**WELWYN HATFIELD BOROUGH COUNCIL
EXECUTIVE DIRECTOR - PLANNING, PUBLIC PROTECTION AND GOVERNANCE**

DELEGATED APPLICATION

Application No: 6/2022/0441/FULL
Location: 12 Southfield Welwyn Garden City AL7 4ST
Proposal: Retrospective change of use to plant hire (resubmission following refusal of 6/2021/1380/FULL)
Officer: Mr Raymond Lee

6/2022/0441/FULL

SCALE:	DATE:	DRAWN:	CHECKED:	APPROVED:
1:500	12/08/21	SMK	RJM	RJM
JOB NO:	DRAWING NO:	REVISION:		
2104-021	SP02	A

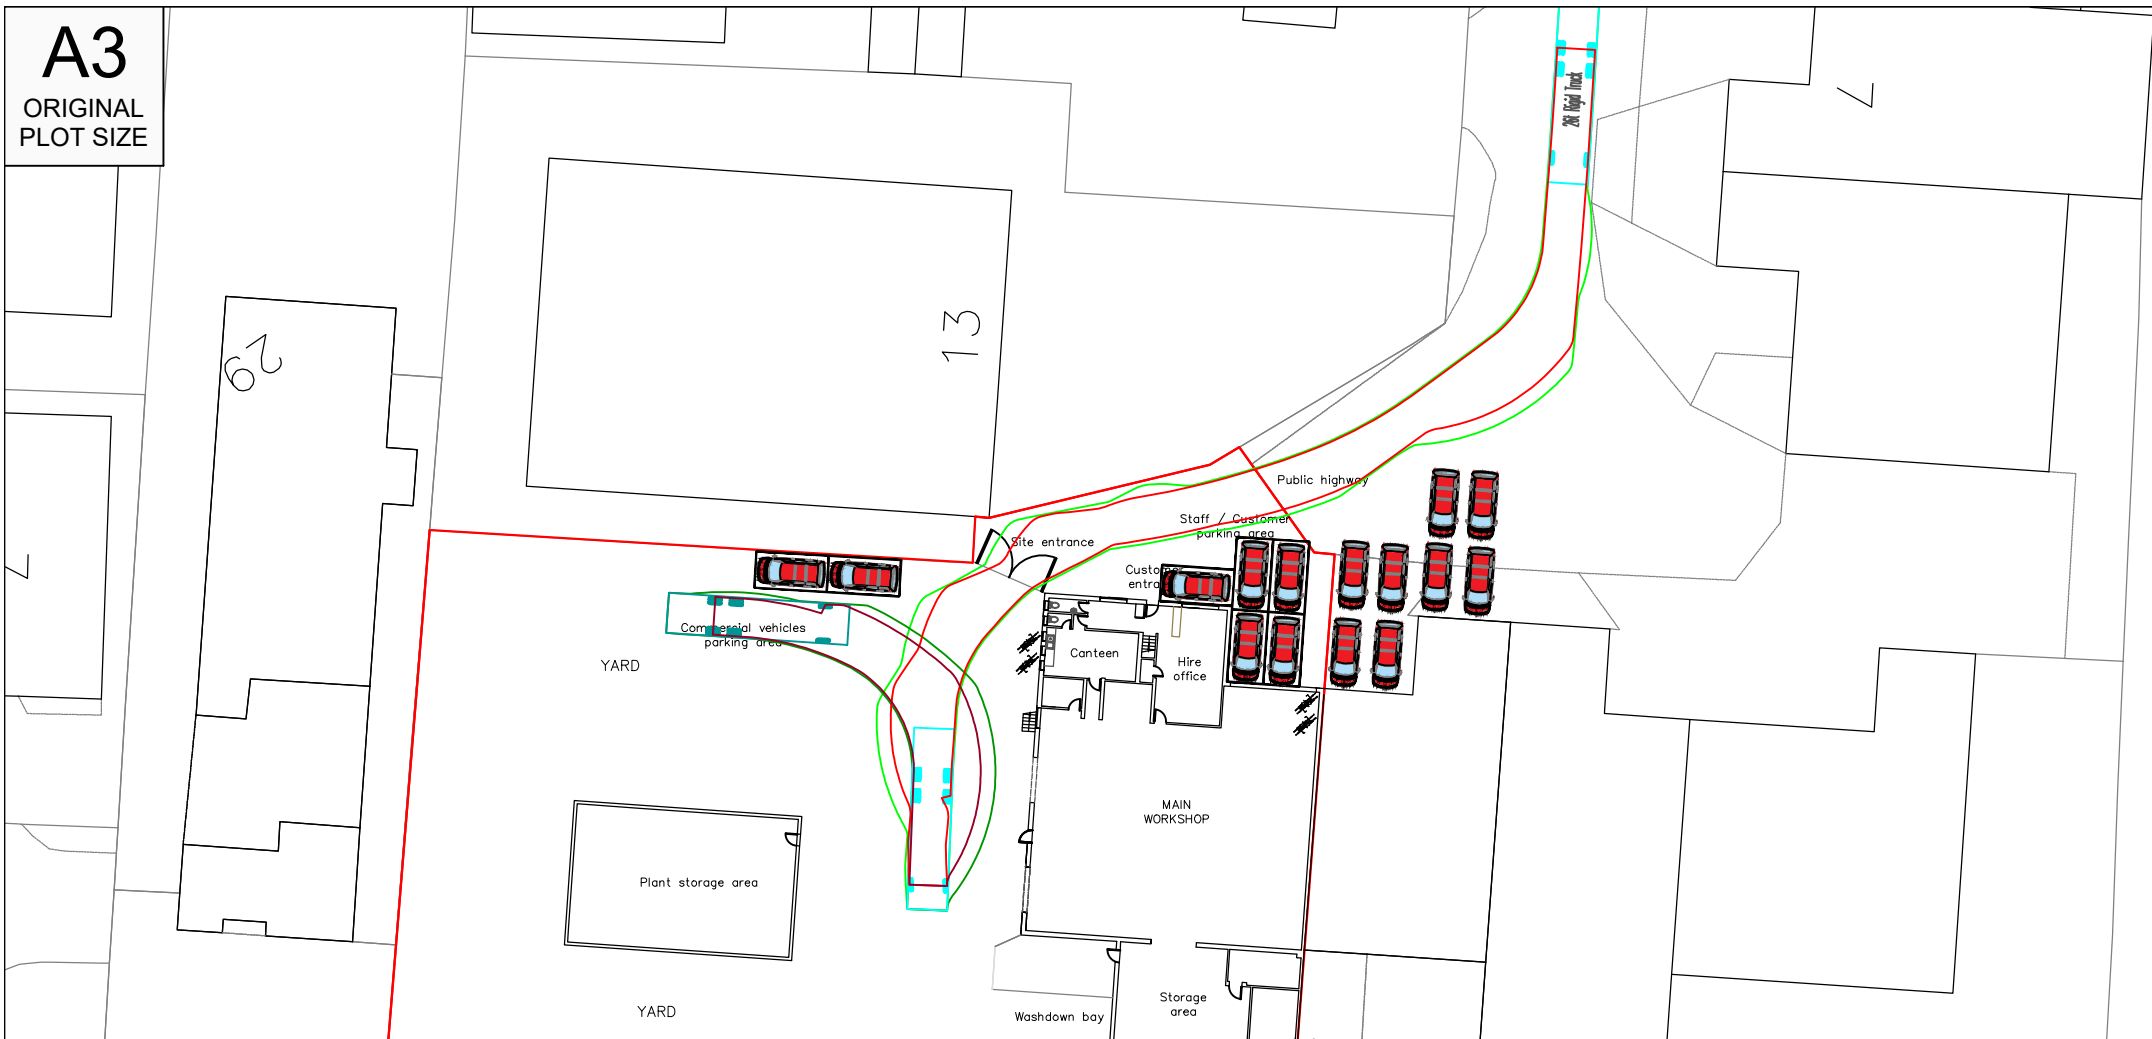
In terms of access and servicing, the submitted details demonstrate the largest vehicle to be used in association with the business (12mx2.55m 26 tonne rigid truck) can enter/exit in forward gear and sufficiently turn on-site within the yard area. Therefore no objection was raised by the Highways Authority subject to a

2. The turning area shown by the Swept Path Analysis Drawing No. SP02 Rev. A of the Transport Survey must be retained and kept clear at all times for loading and unloading purposes of all deliveries, servicing and operational vehicles at the site.
